# City of Albuquerque Stormwater Construction Site Inspection Report

ESC File No.	M15E021C	Project Name:	Dutch Bros. NM0303		
NPDES Id. No.	NMR1005GM	Location:	2131 Gibson Blvd SE		
9/6/2023	Owner		Contractor		
Operator	Dutch Bros, LLC				
Contact name & title	Daniel Batty				
e-mail	<a href="mailto:daniel.batty@dutchbros.com">daniel.batty@dutchbros.com</a>				
Contact Phone #	541-955-4700				
COA Inspector	Chancellor English		Start/End Time:	330pm	
Construction Phase:	Grading, foundation				
Type of Inspection:	Regular	Storm Event	Post Storm Event >0.25"	311/Complaint	Follow Up
Weather at time of inspection?	Clear		Temperature: ~	90	
Estimated date of last storm 0.25" or greater	8/8/2023

Title:  
EROSION AND SEDIMENT CONTROL PLAN  
SWC GIBSON BLVD AND YALE BLVD  
ALBUQUERQUE, NM 87121

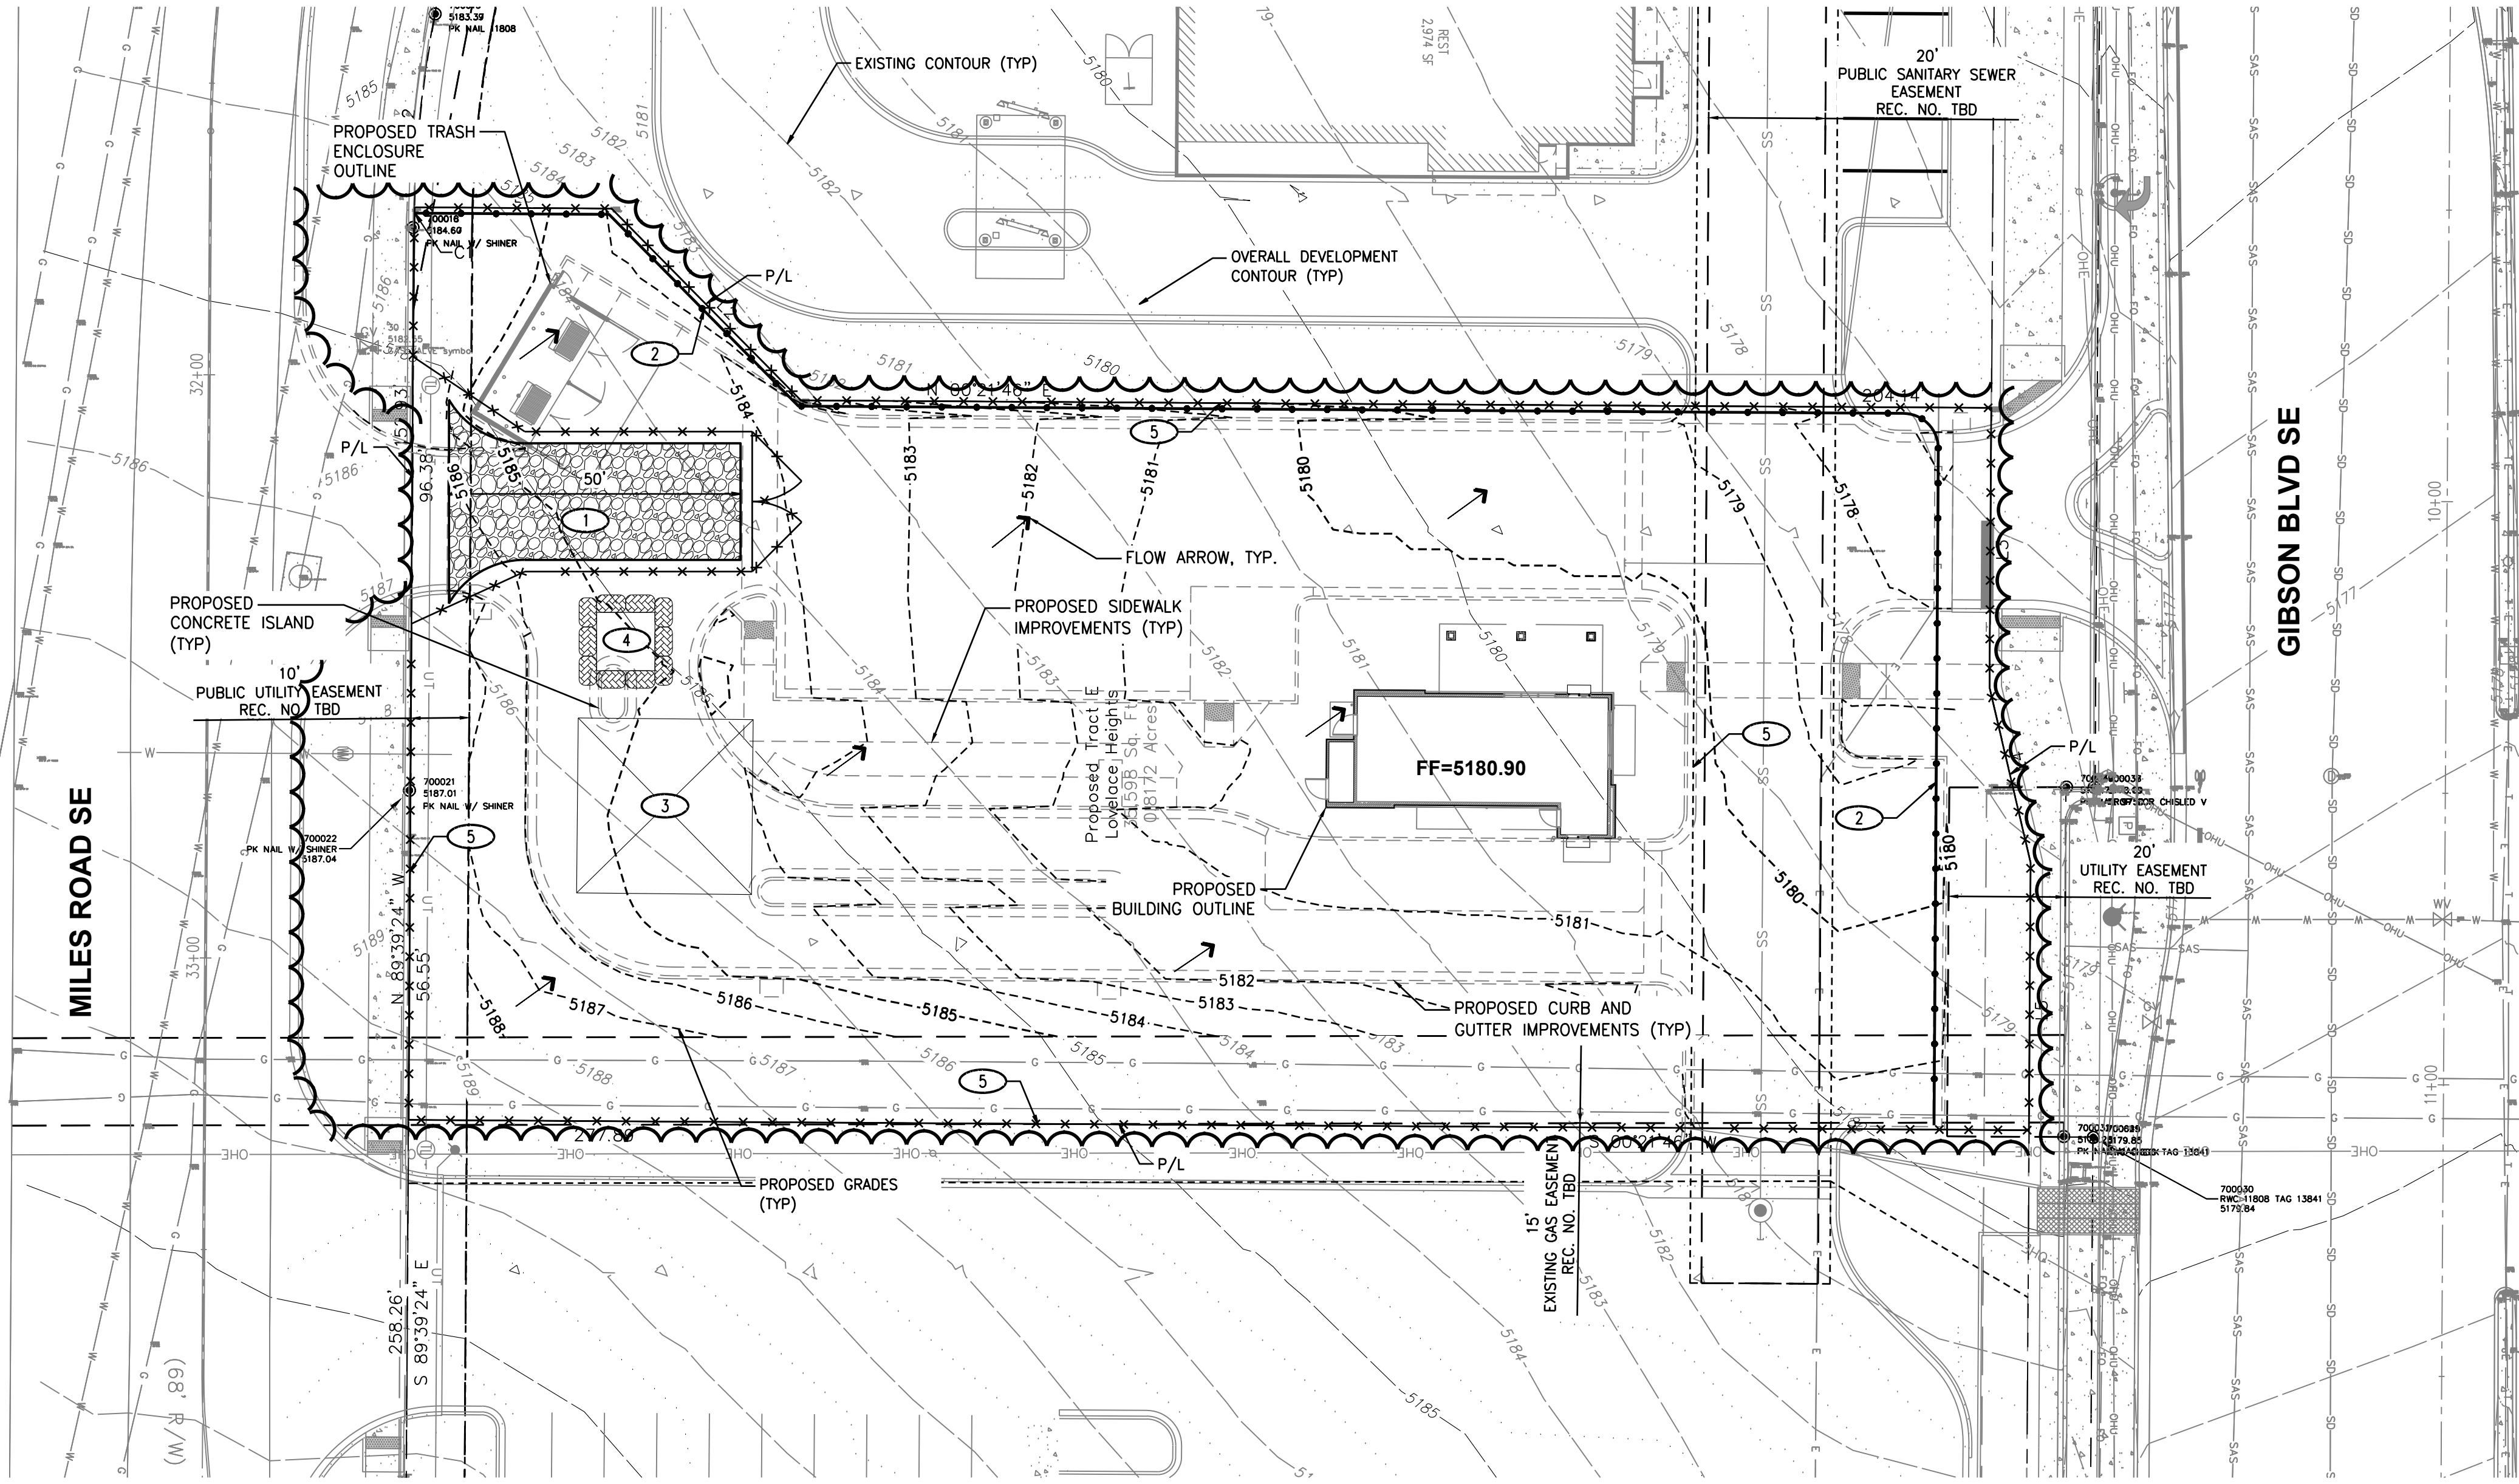
Item Number	Deficiency/ Corrective Action				
1	There was no permit coverage posting located at or near the site. Required mitigation: You must post a sign or other notice of your permit coverage at a safe, publicly accessible location in close proximity to the construction site, and the notice must be located so it is visible from the public road that is nearest to the active part of the construction site per CGP Part 1.5.				
2	The SWPPP and self-inspection reports were not available at the time of inspection in violation of CGP Parts 4.7.3 and 7.3. Required mitigation: You must keep a current copy of your SWPPP and a copy of all inspection reports at the site or at an easily accessible location so that it can be made available at the time of an on-site inspection per CGP Parts 4.7.3 and 7.3.				
3	At the time of the inspection, the BMP installations were not complete before land disturbing activities had been initiated. The perimeter silt fence was not complete and the construction entrance was not yet installed while excavation was in process in violation of CGP Parts 2.1.3, 2.2.3, and 2.2.4. Required mitigation: You must complete the installation of stormwater controls by the time each phase of construction has begun per CGP Part 2.1.3. Install sediment controls along any perimeter areas of the site that are downslope from any exposed soil or other disturbed areas per CGP Part 2.2.3. You must minimize sediment track-out by restricting vehicle use to designated exit points and use appropriate stabilization techniques at all points that exit onto paved roads per CGP Part 2.2.4.
